# CITY OF ALBUQUERQUE

February 6, 2025

**RE: Kairos Power Expansion SP  
5201 Hawking Drive SE  
Grading and Drainage Plan  
Engineer's Stamp Date: could not find  
Hydrology File: Q16DA5000A**

DRAWN	EJO	CHECKED	AS	APPROVED	CS	DATE	7-30-24
SCALE	1"= 20'	DRAWING NUMBER	218356	PROJECT	KPS-SLT-K11-900-1-008	REV.	2

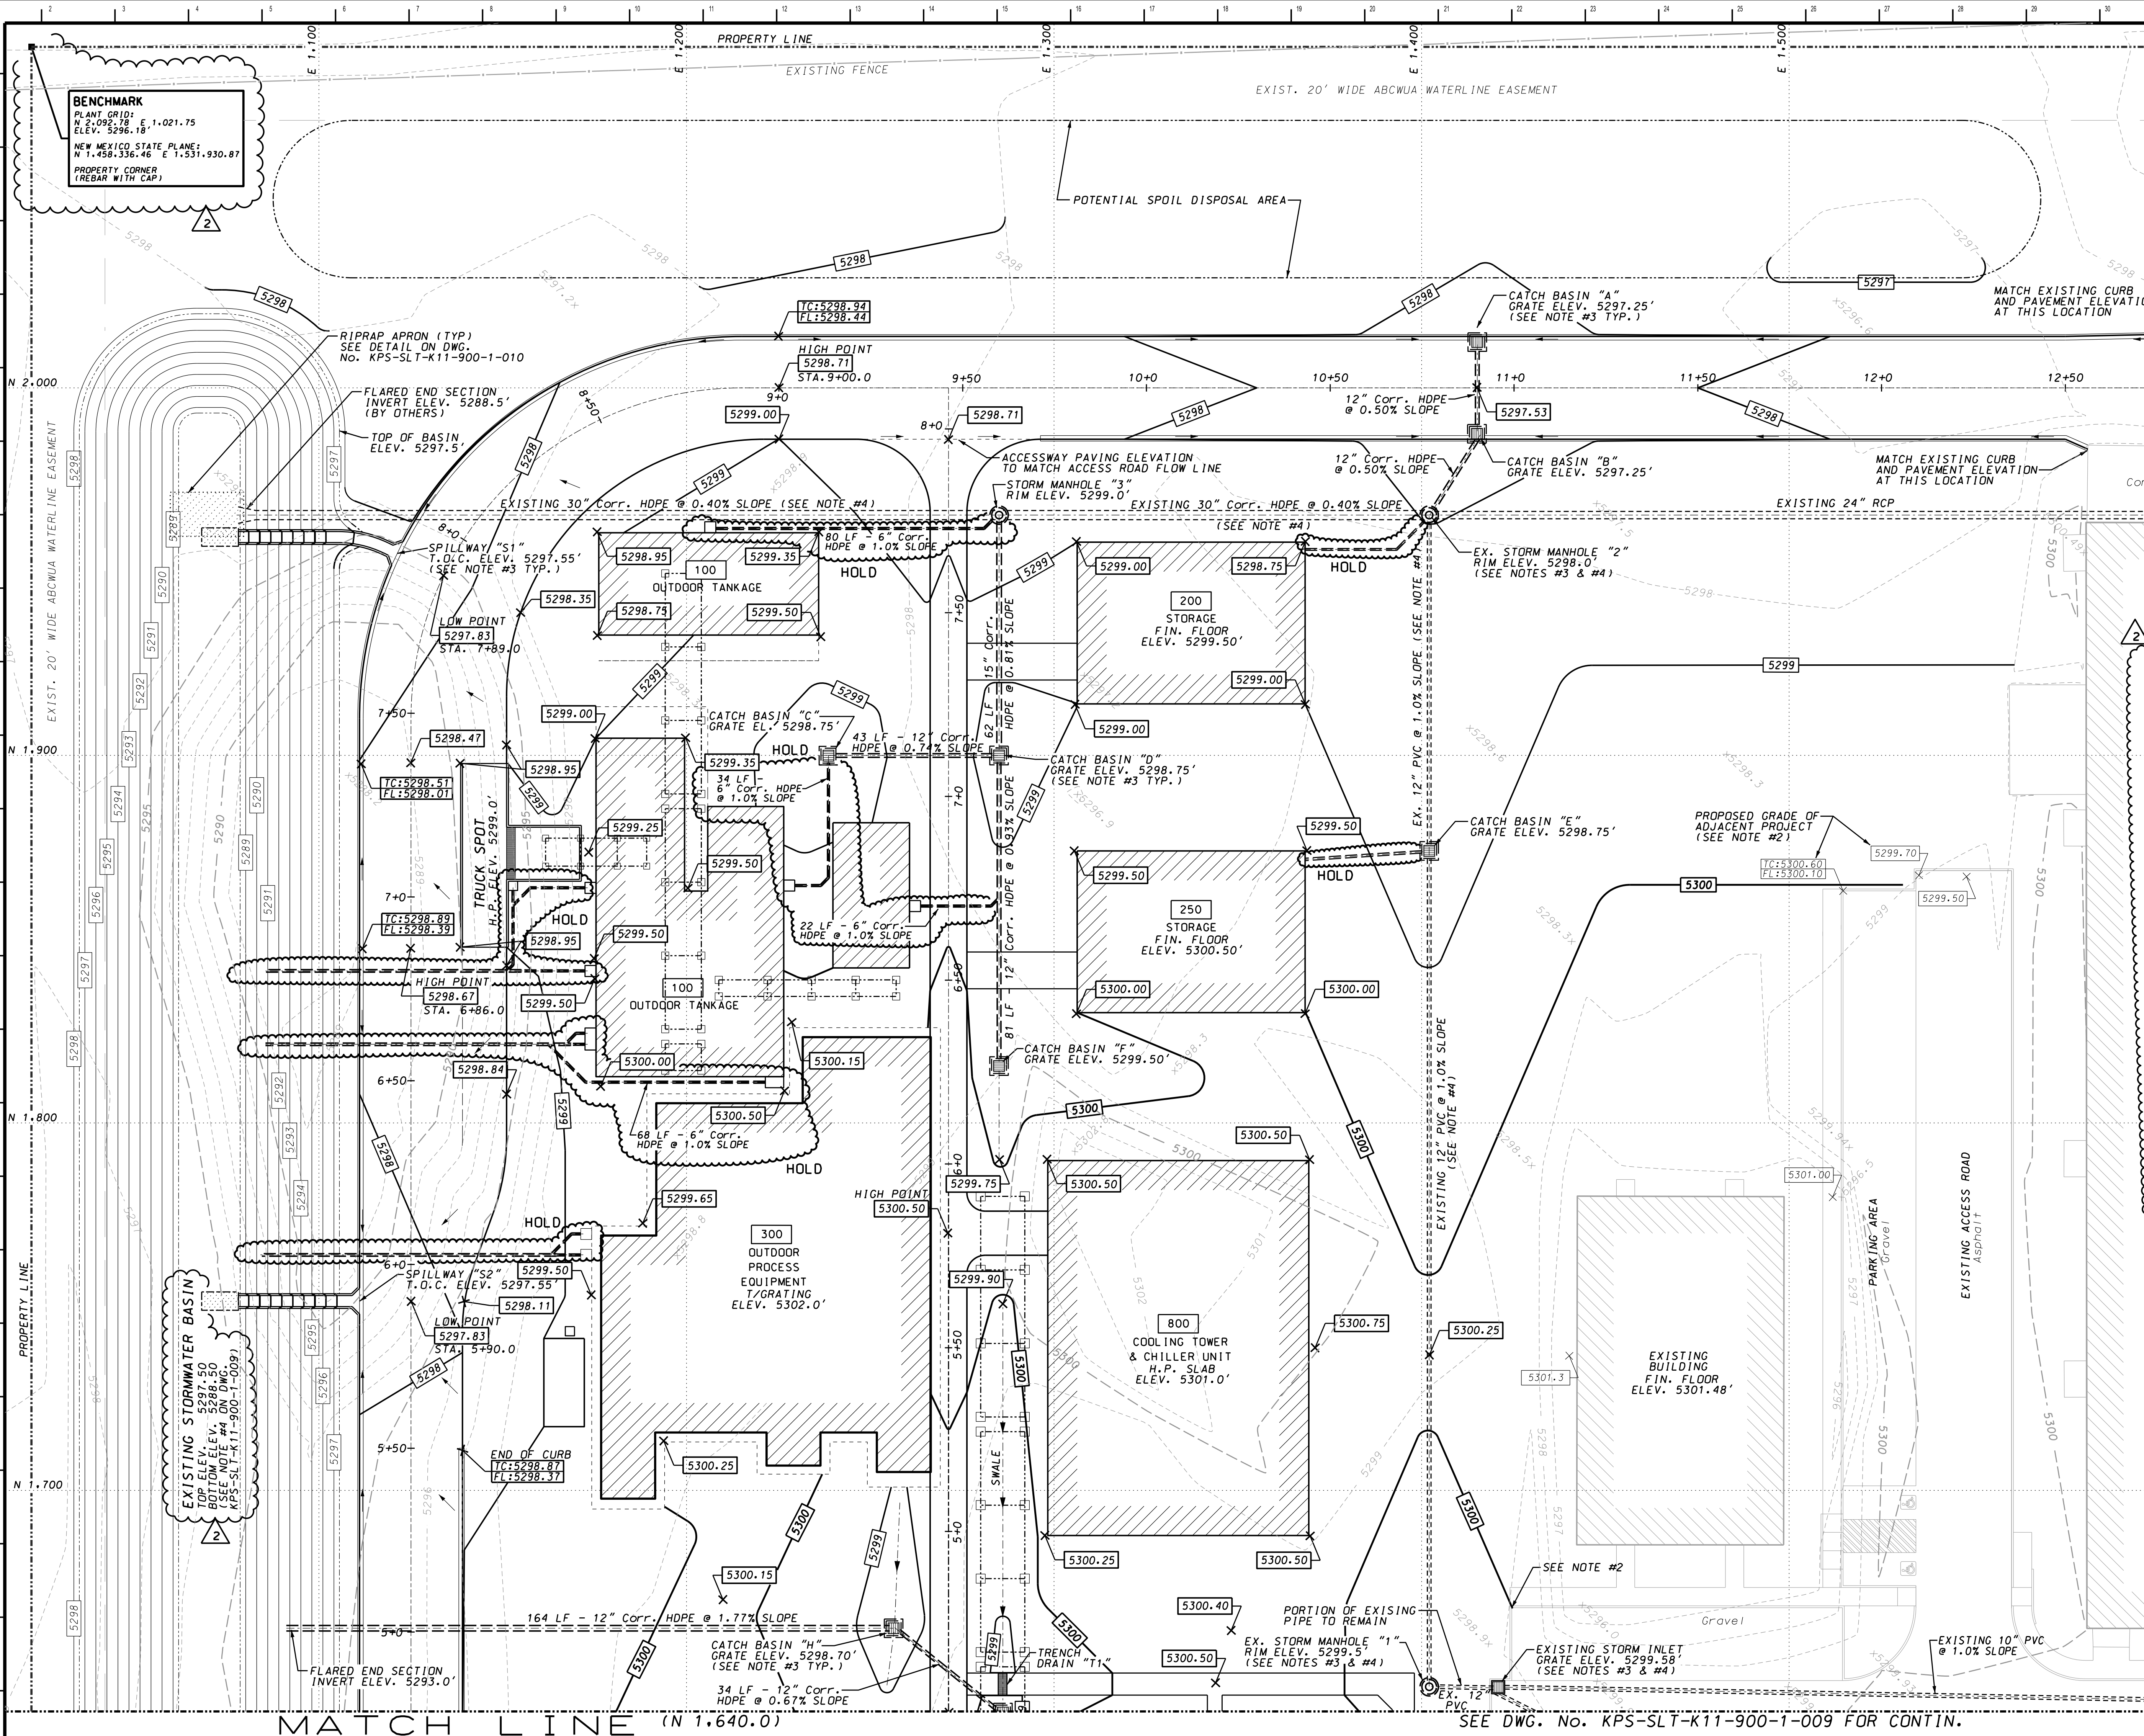
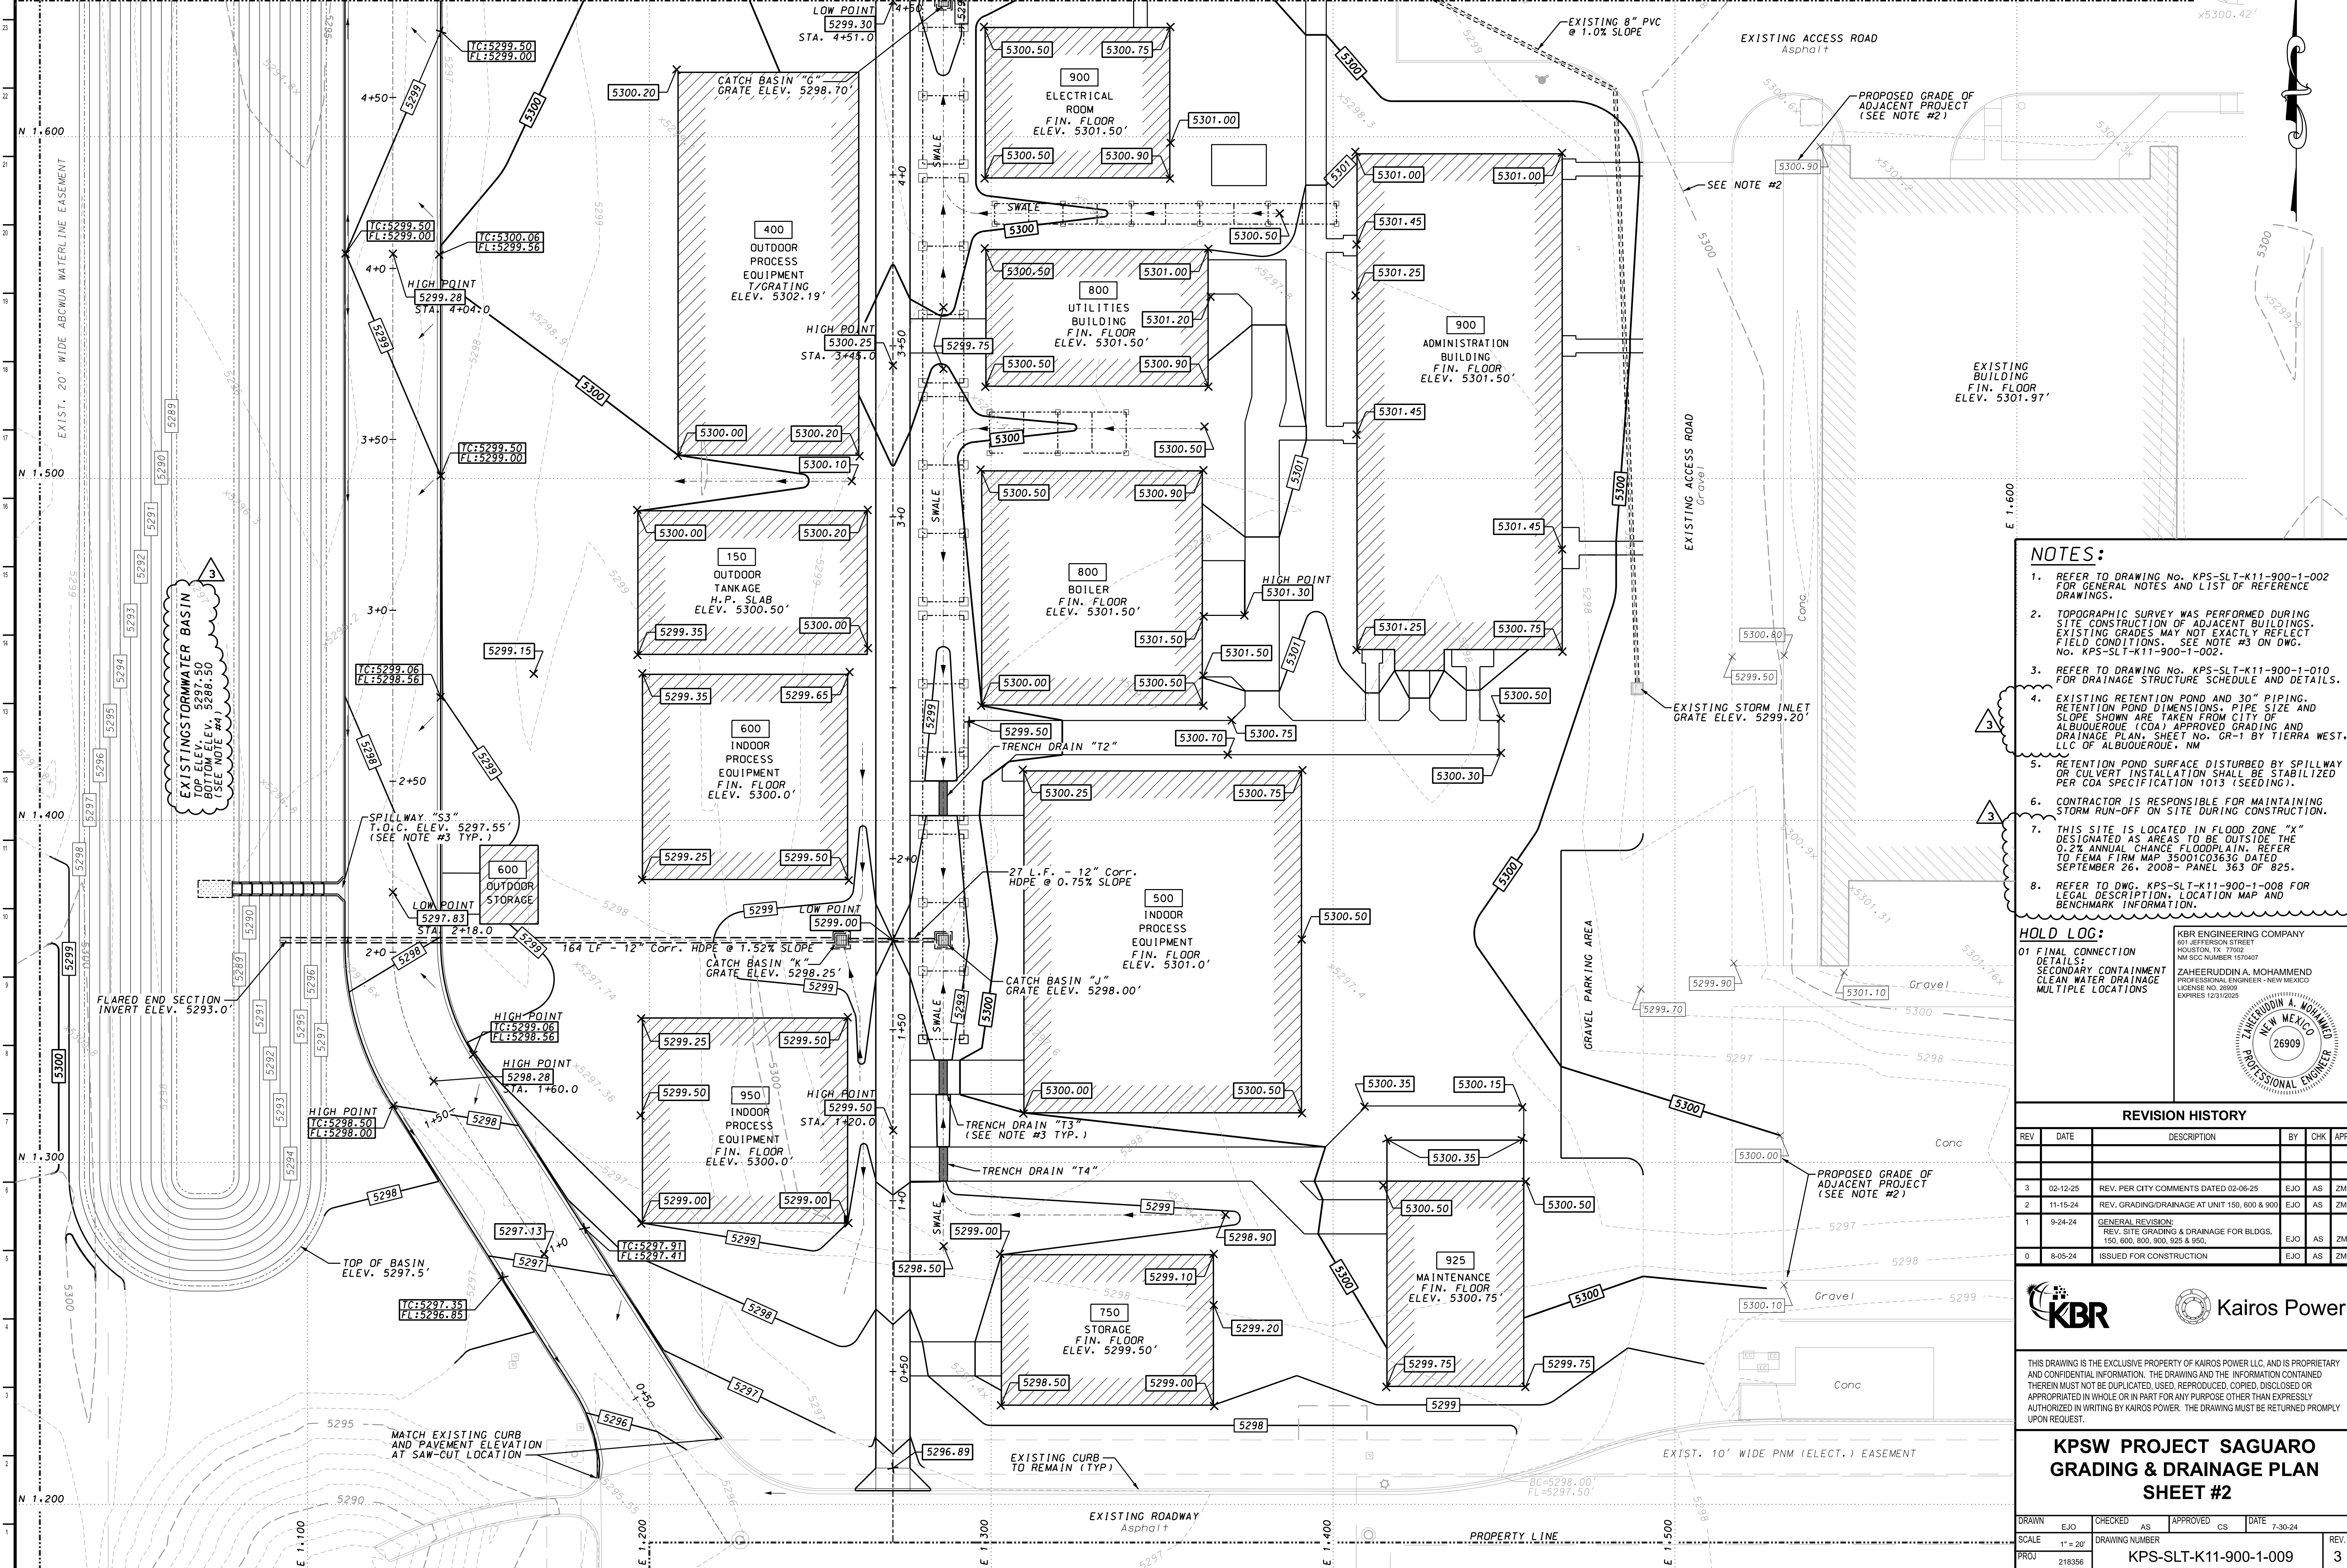
1. Since the retention pond on the west side of the lot is already constructed, change the note to EXISTING STORM WATER BASIN and remove the "(BY OTHERS)" note on sheet 008 and 009.

2. Update the NOTES section – Note #4 - update per comment #1 above.
3. Per the DPM, the following must be on the Grading Plan. Please note the Grading Plan must be a stand-alone construction document.
